URBAN DESIGN COMMENTS

Site Address: Tudor Lodge Hotel, 50 Field End Road, HA5 2QN
Planning ref: 4726/APP/2023/2216
Case Officer: Nesha Burnham
Design Officer: Joris van der Starre
Date of comments: 04/10/23
Proposal: Alteration to car parking layout, resurfacing and expansion of hardstanding. Installation of a sunken paving area with pergola and a standalone outbuilding for WC and store. Installation of a staff cycle shelter. Erection of a boundary fence and planting against Field End Road. Various landscape planting and paving to external pergola sitting area.

Tudor Lodge Hotel, Field End Road

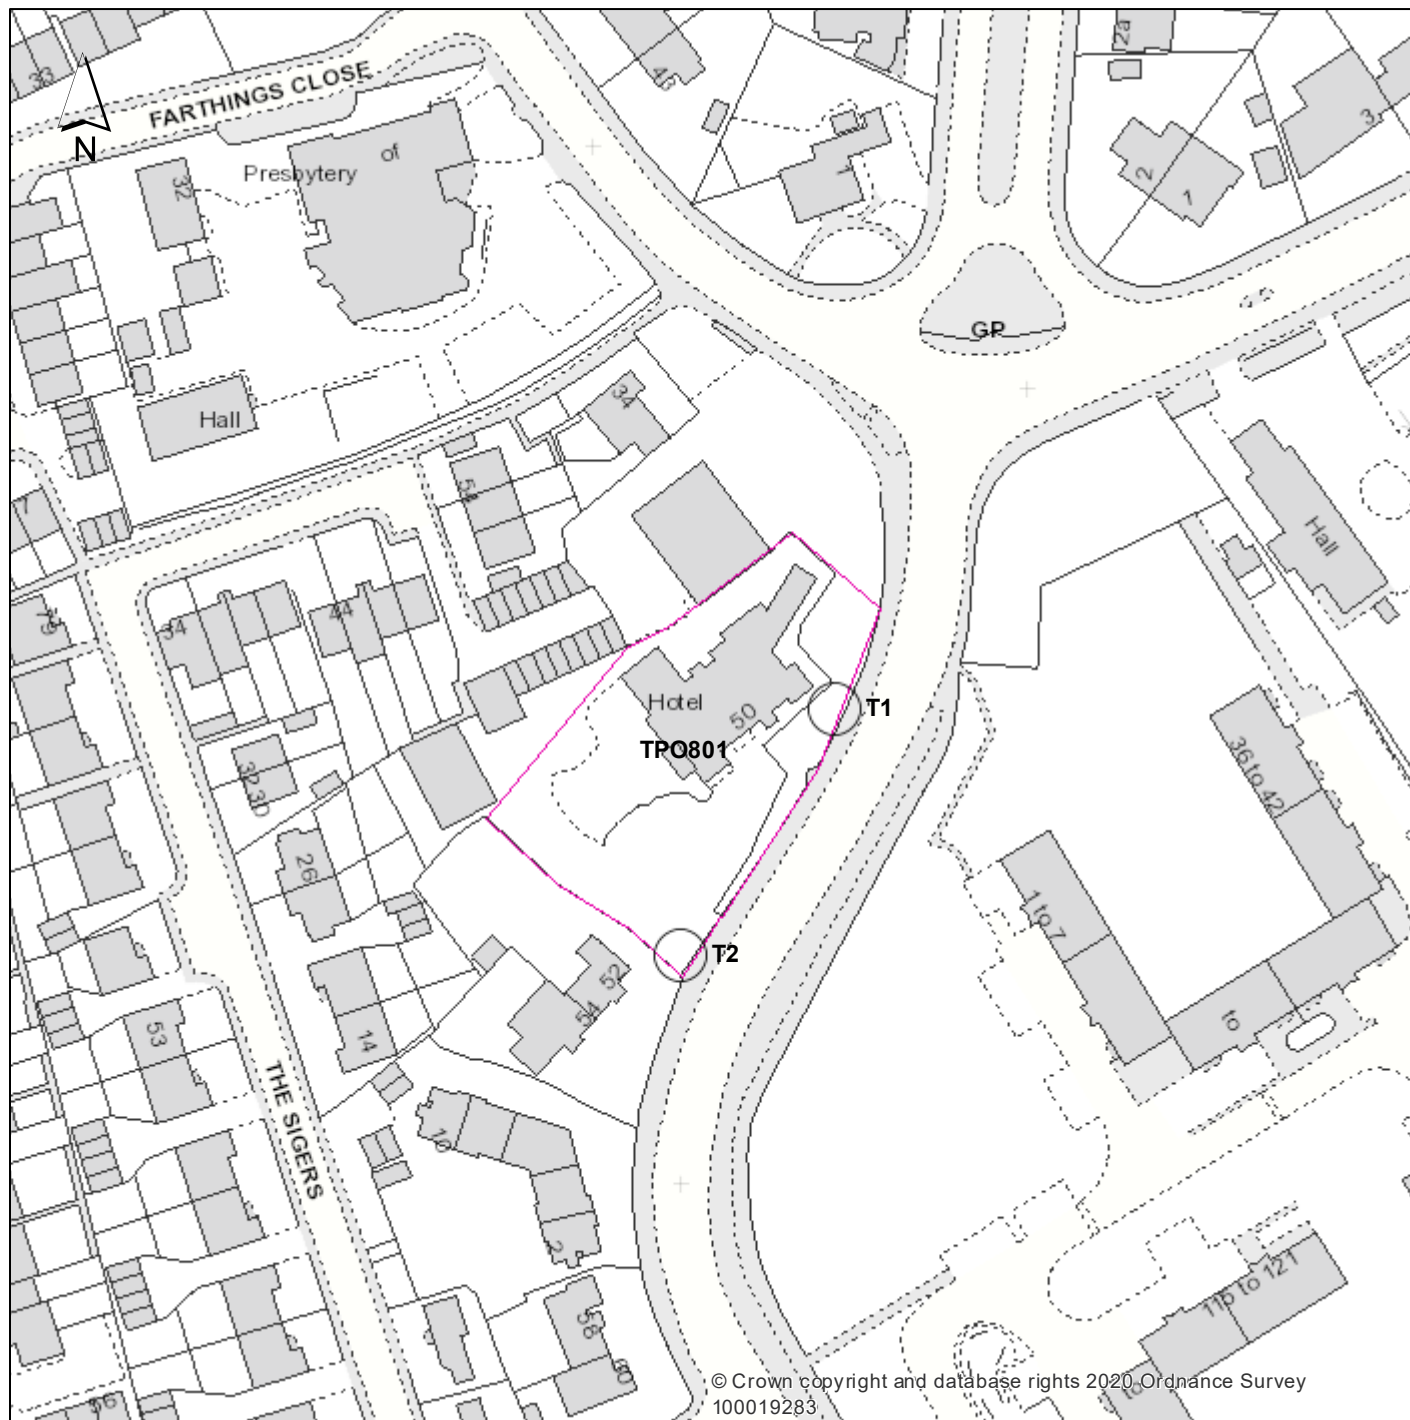
Recent changes have been made to the frontage, including a new white picket fence, removal of a hedge and various trees, and new planting including conifer type trees. It is unclear whether these changes benefit from planning permission. The hedge and trees along this frontage (visible in Fig.9 and removed in Fig.8 of the DAS) were within a Tree Preservation Area (TPO 801). Removal of TPO trees is generally not supported and no mitigation seems to be proposed.

Apart from the already felled trees along the frontage, several more trees (at least 4) are proposed to be removed, at least one of which seems to be within the TPO area. There is no arboricultural report detailing the existing trees, nor confirming the total number and quality, value and mitigation measures. Therefore, the proposals are not supported.

JW: As part of application, we have submitted both Arboriculture impact assessment and method statement by Cantia & landscape design by Studio Loci. Those reports do not seem to have passed onto Joris van der Starre for review. As always we can provide additional info & clarification if required.

JW: [As part of application, we have submitted both Arboriculture impact assessment and method statement by Cantia & landscape design by Studio Loci. Those reports do not seem to have passed onto Joris van der Starre for review. As always we can provide additional info & clarification if required.](#)
